Re: Seven Clover
3641 12th St NW
Site Plan
Architect's Stamp 8-27-23 (G14D062)

Based upon the information provided in your submittal received 12-4-23, the above referenced plan cannot be approved for Building Permit until the following comments are addressed:

AS101

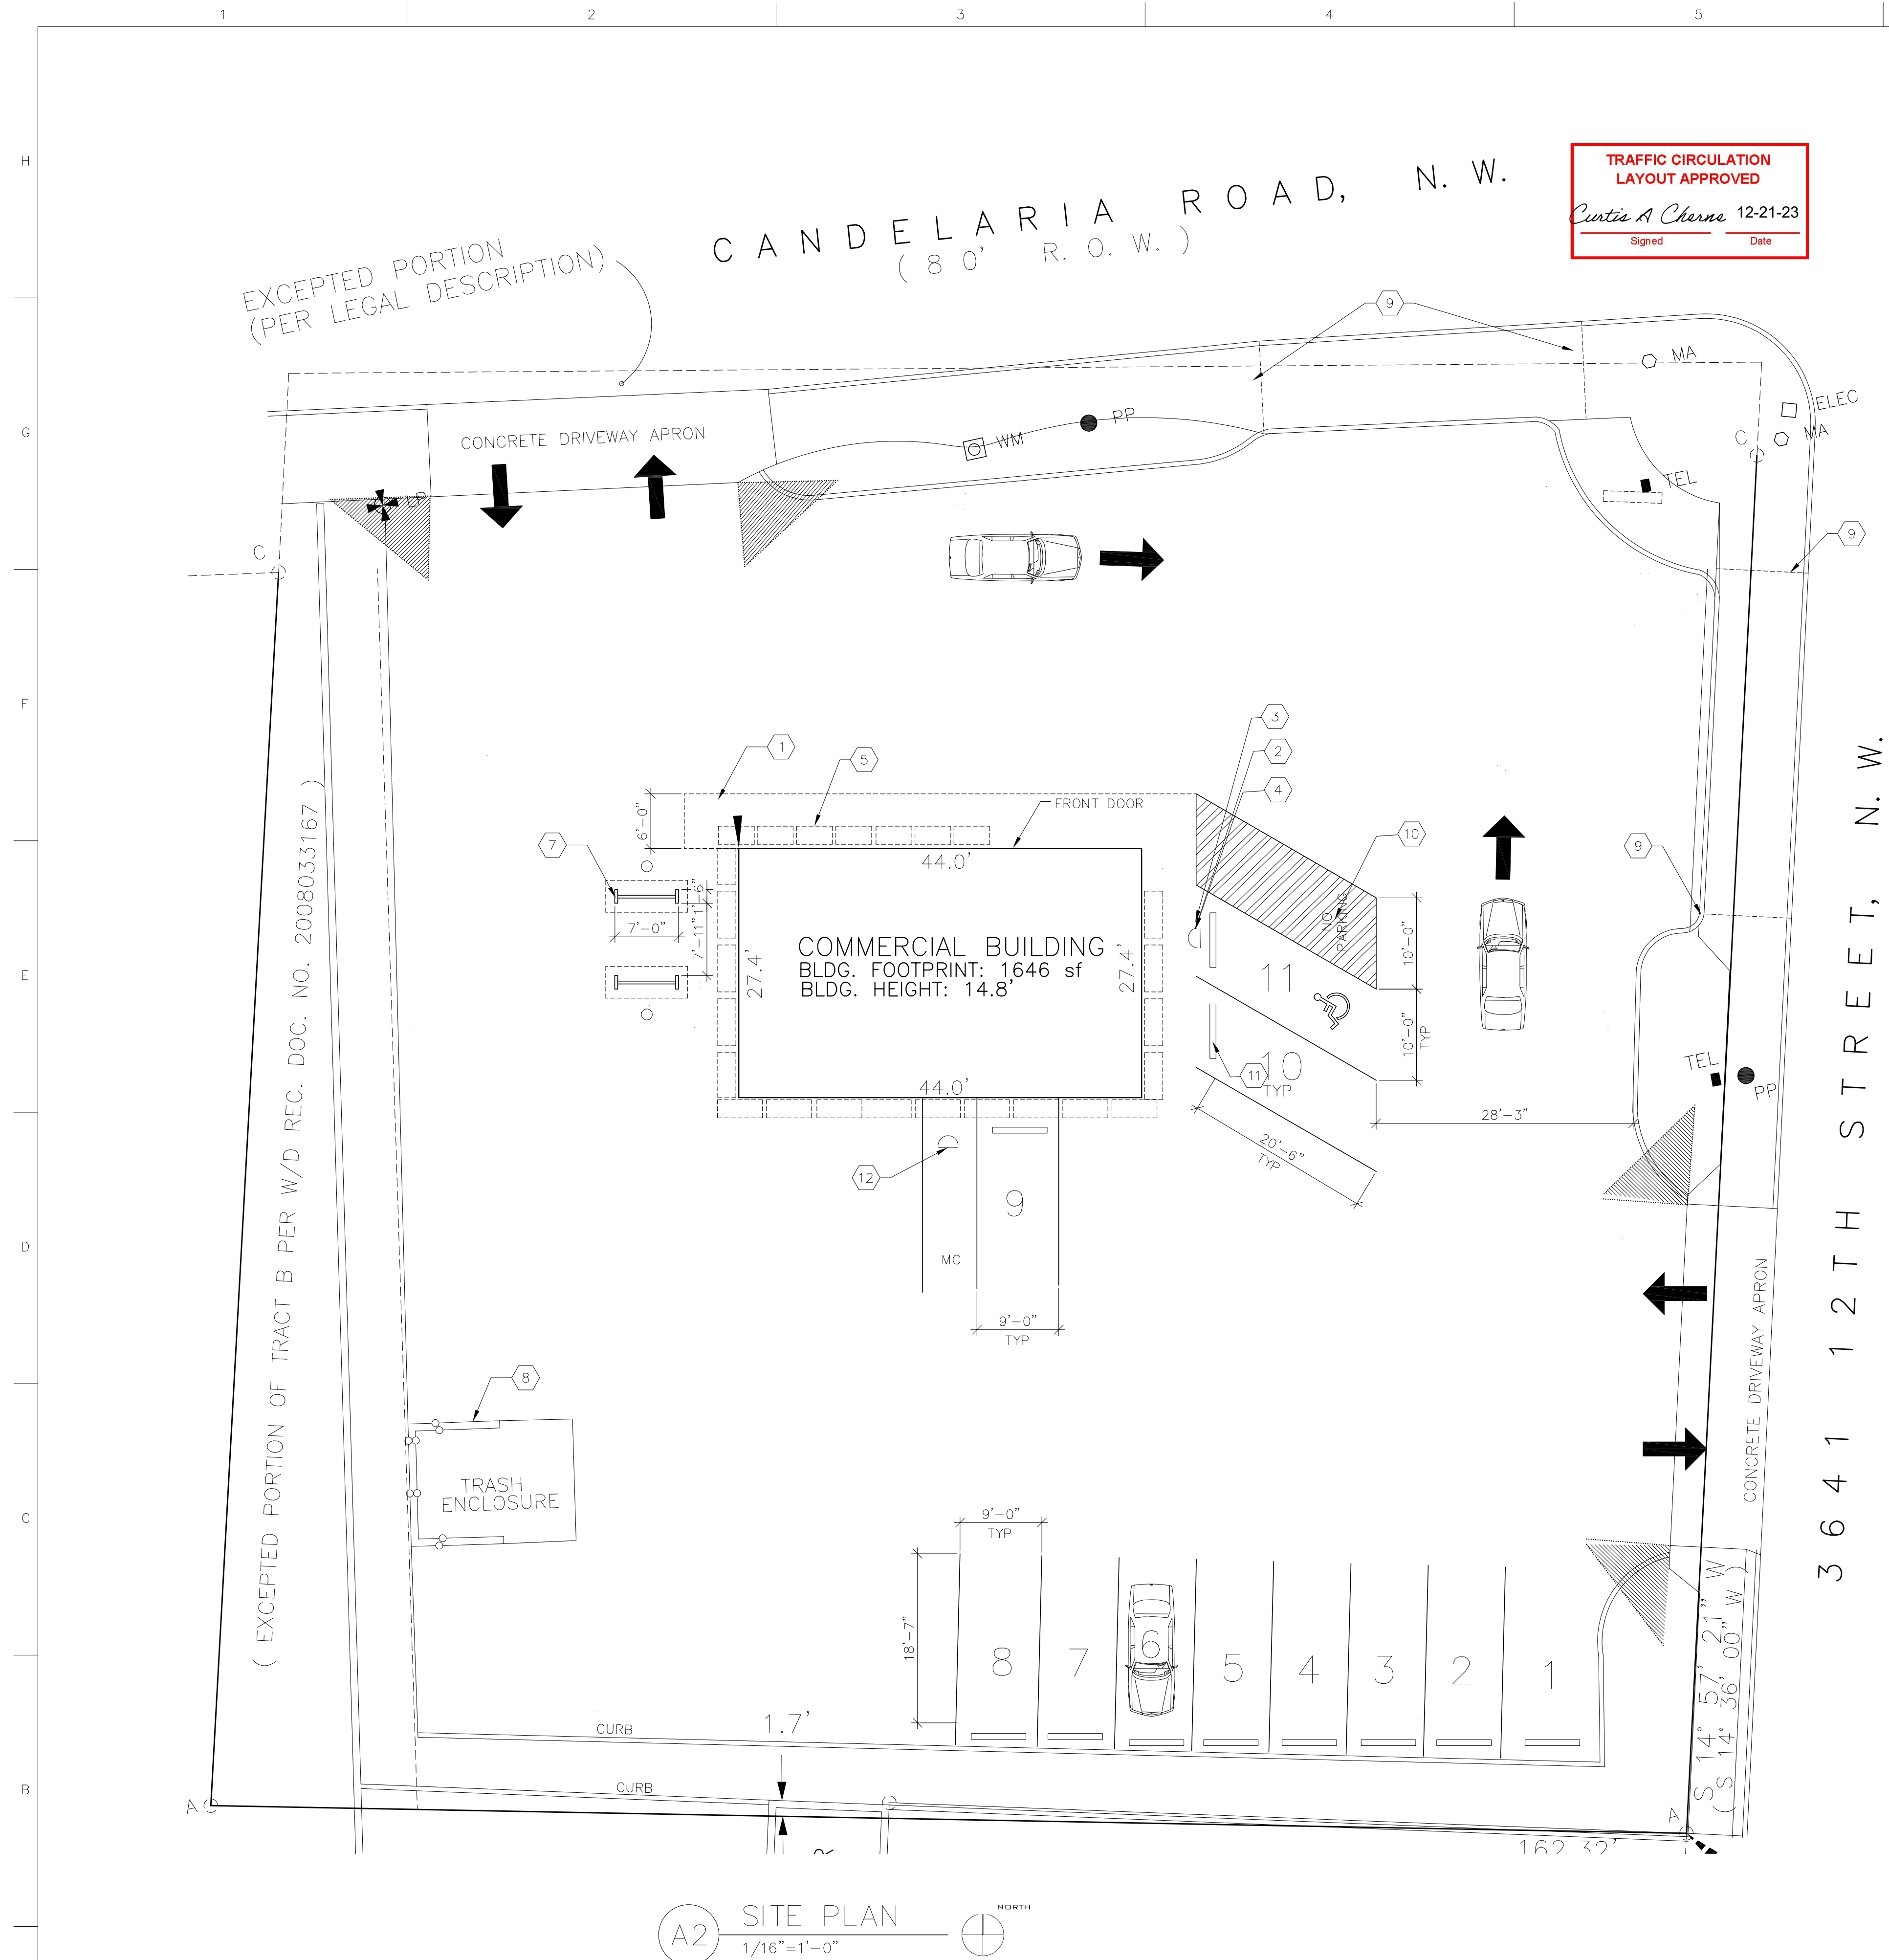
3. Provide the use of the building per the IDO, rather than "Commercial Building", so parking requirements are known.
4. Provide the required amount of parking and the provided amount of parking.
5. Show the location of the front door.

6. Please explain the purpose of Note 6 as it applies to this submittal or remove it.
7. Show the mini clear sight triangles at both drive pads.
8. Keyed Note 9 and Note 7: You could delete Note 7 and Keyed Note 9 could read "Remove existing drive entrance. Replace with curb and gutter per COA STD Dwg 2415A and construct sidewalk per COA STD DWG 2430, matching adjacent sidewalk width and color.

9. Note 7 should be removed or rewritten. You don't need a drive-pad drawing as the drive-pad is being removed and this plan should include all notes for constructing transportation related items.

10. Provide the dimension for the angled parking, including the angle.
11. The drive aisle near the Candelaria entrance is labeled s 4'-9" wide. The minimum for 2-way traffic is 22 feet.

12. Show the 6' ADA accessible route from a City ROW to the front door.
13. I could not locate the leader for Keyed Note 1.
14. It appears the leaders for Keyed notes 2,3 and 4 are for the handicap parking rather than for the motorcycle parking. For motorcycle parking you just need a motorcycle parking sign, which are 12" x 18" rather than the 12" x 12" as shown. Some designers put an "MC" in large letters at the entrance to the motorcycle parking stall.

15. Handicap (HC) parking:
 - a. Signage: See image attached to the email. Remove non-compliant sign images "Reserved Parking".
 - b. Note 2: refers to signage, where it should refer to a pavement marking. Recommend putting this in the Keyed Note area.

- c. HC parking should be near the front door.
 - d. Please add a length dimension to the HC parking stall.
 - e. The HC sign should be in front of the parking space, rather than in front of the "No Parking" aisle.

16. Keyed note 5 refers to "2'x5'-2" – gabion...". Are they to be constructed on the walking surface as shown?
17. It appears there is a sidewalk to be built around three sides of the building. Provide build notes, including the width. This may necessitate the need for a handicap ramp.

18. Bicycle parking:
 - a. Parking is to be separated from vehicle parking areas and driveways by a barrier such as a curb or bollard.
 - b. Keyed Note 7 references Notes 9 and 10 and Detail C6, which don't exist. Please revise note and provide Detail C6.

- c. You will most likely need to provide 3 bicycle parking spaces.
19. Provide Fire and Solid Waste Dept. approvals.
